Sea Link Energy Cable

**Appendix A3 to the Natural England Deadline 3 Submission  
Natural England's comments on Suffolk Onshore Ecology matters**

Planning Inspectorate Reference EN020026

9<sup>th</sup> January 2026

**Figure 1. Landfall Concept Drawing (see page below)**

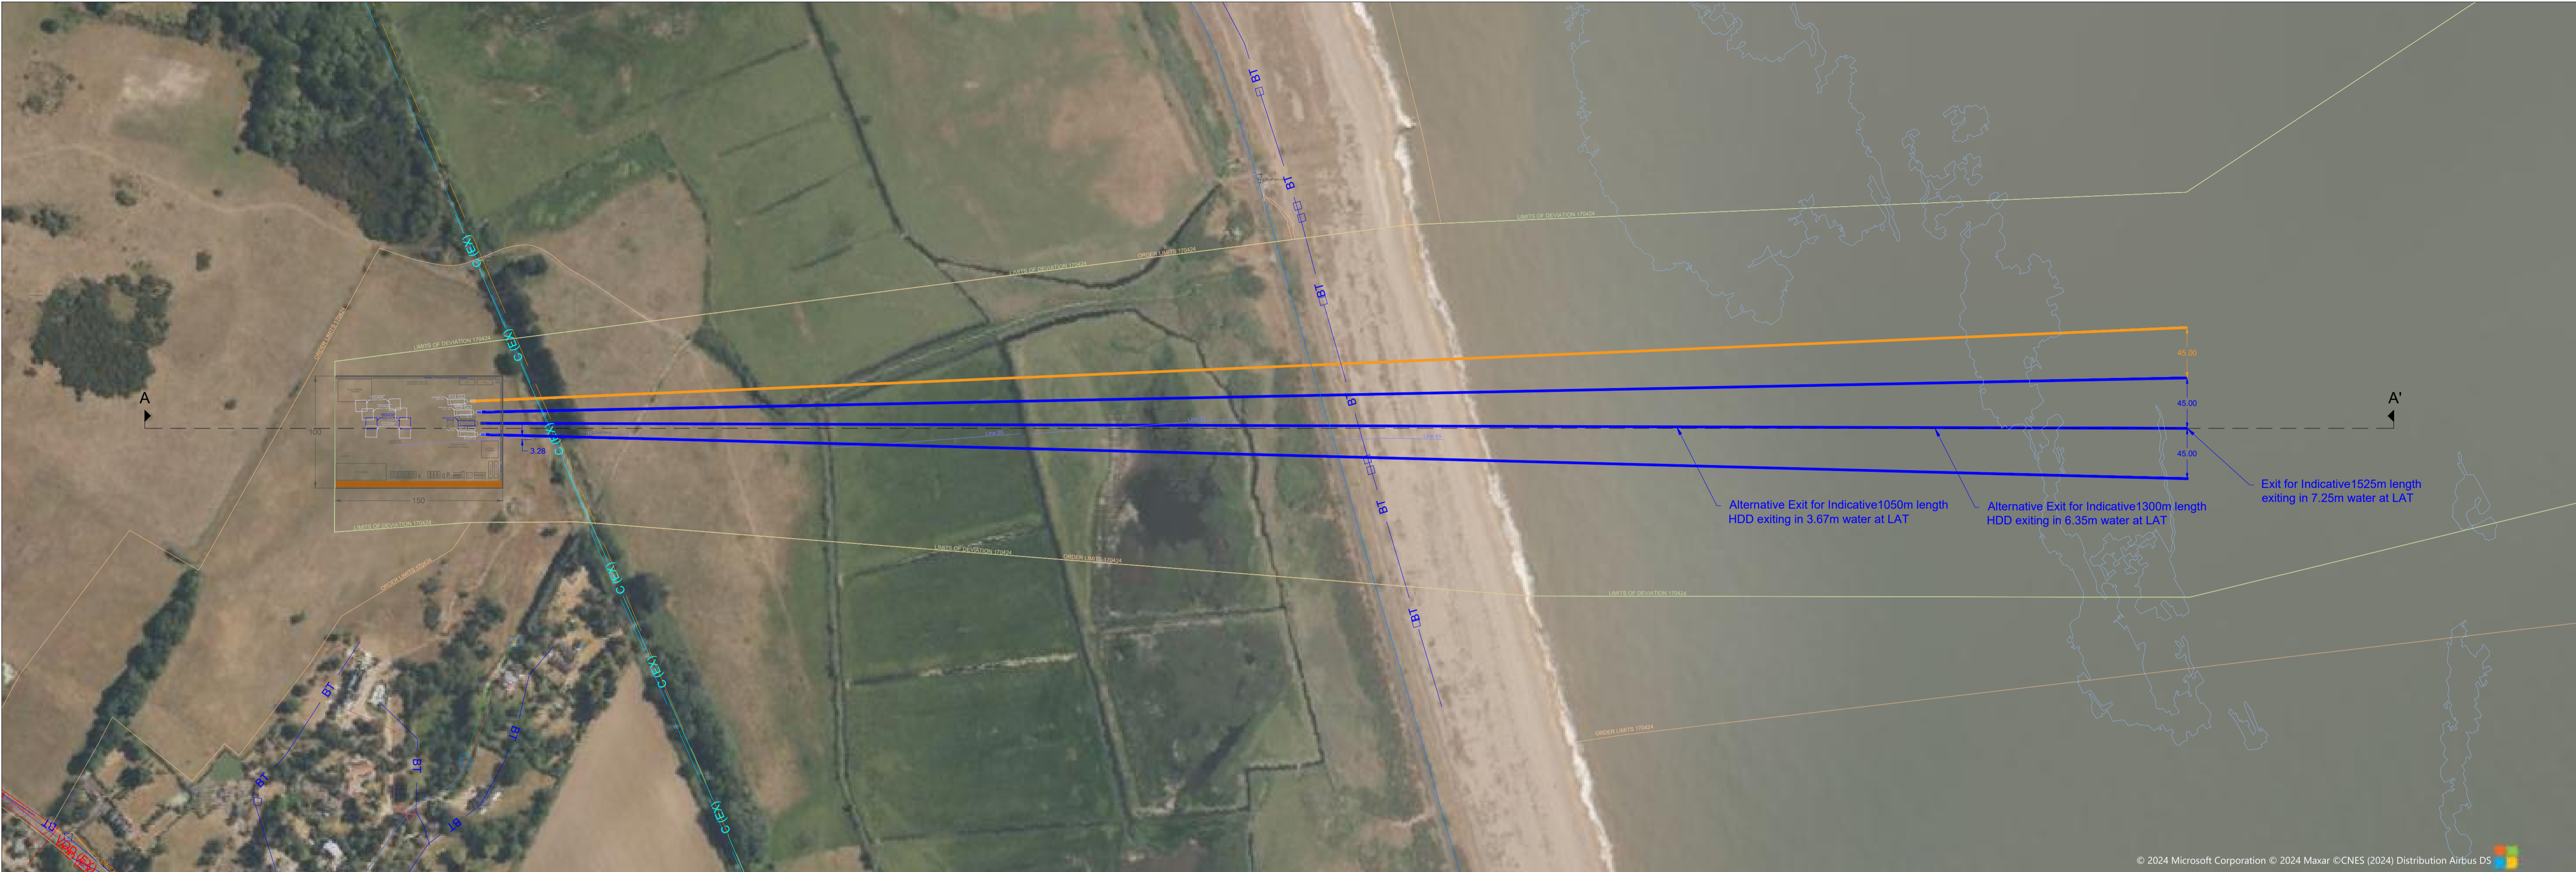
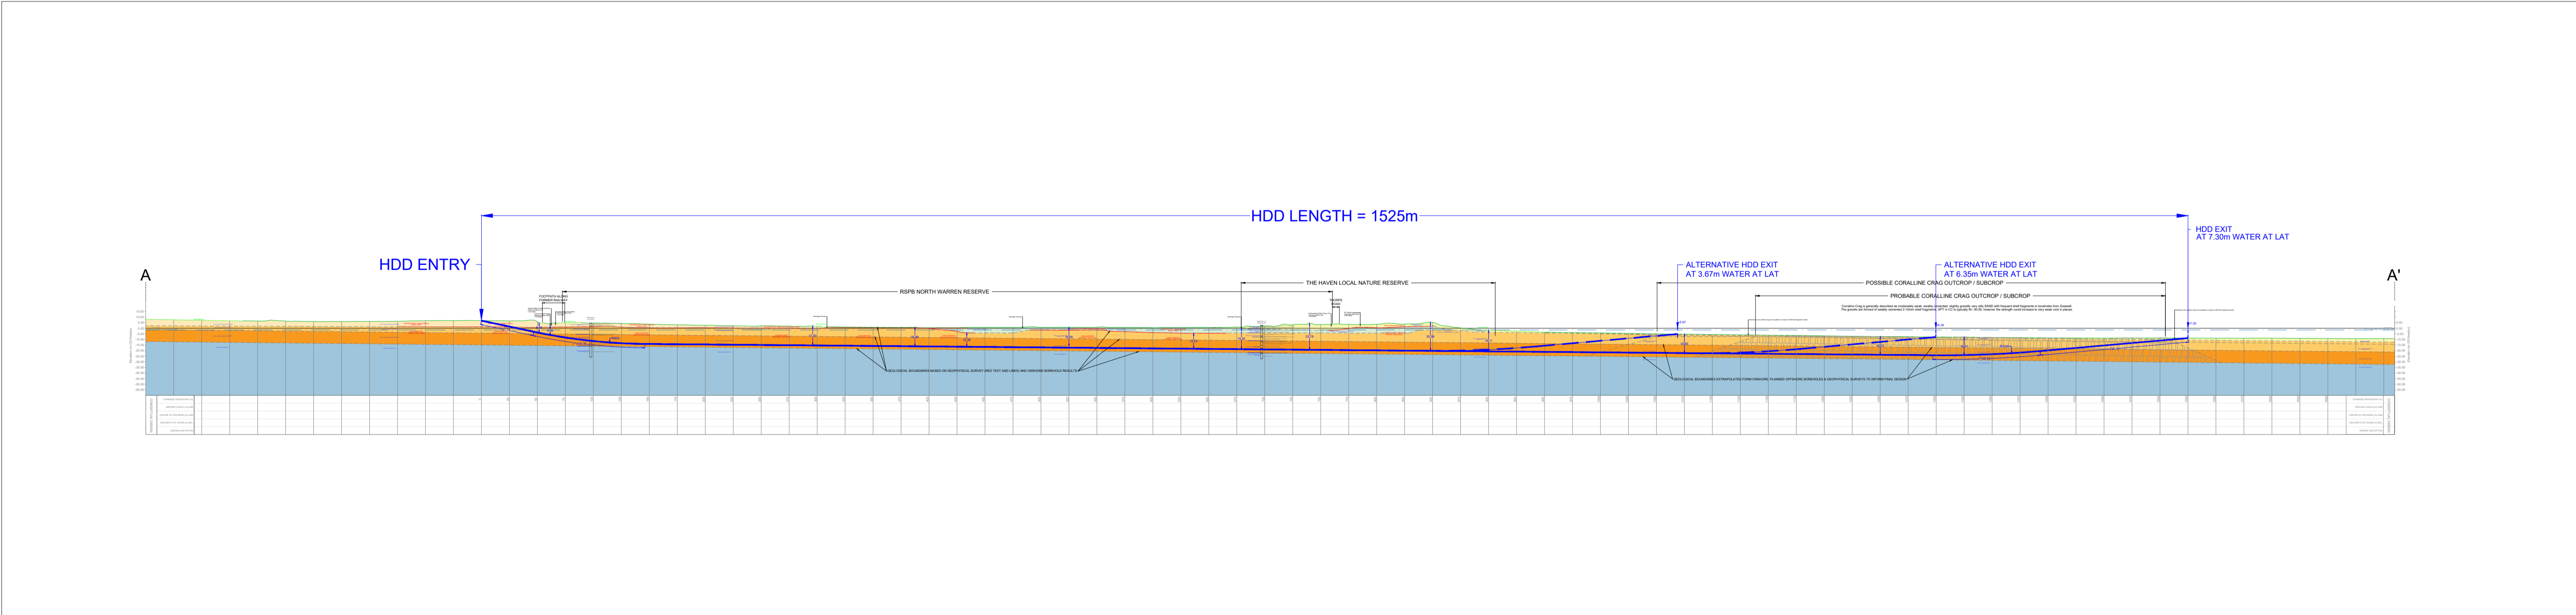
NE Ref	Section/Para	Key Concern and/or Update	Natural England's Advice to Resolve Issue
		<p>protection placed in the area should be assessed, particularly where currently the bedform is mobile in nature.</p> <p>Figure 1 Landfall Concept Drawing shows that all three HDD exit points will drill through Coralline Crag. No assessment of potential impacts to this geological feature is provided.</p>	
<b>Document reviewed:</b> [REP1-048] 6.2.2.2 (C) Part 2 Suffolk Chapter 2 Ecology and Biodiversity (Tracked Changes)			
3	Table 2.5 2.9.16 2.9.8	<p>In Table 2.5 and paragraph 2.9.16 we note that the air quality dust impact zone has been increased to 250m following our advice.</p> <p>In section 2.9.8 we welcome that further details have been provided to explain how equipment would be retrieved should it become stuck during Horizontal Directional drilling (HDD) under Leiston-Aldeburgh Site of Special Scientific Interest (SSSI). However, we note paragraph 2.9.8 states "<i>In the extremely unlikely event that a drilling string cannot be recovered it will be left in situ, having no ecological implications given the depth below ground</i>". We advise that should a drilling string be unable to be recovered, an assessment of the potential impacts, including relating to soils and groundwater, should be undertaken to inform the decision of whether the equipment should be left in situ.</p>	<p>To fully resolve Point 11 we advise that the plan for dealing with HDD equipment if it gets stuck beneath Leiston-Aldeburgh SSSI should include an assessment of potential impacts prior to any decision being taken to leave equipment in situ. We advise an outline HDD management plan is provided and updated through examination.</p> <p>We also advise that a condition should secure submission and agreement of the final method statement prior to construction.</p>
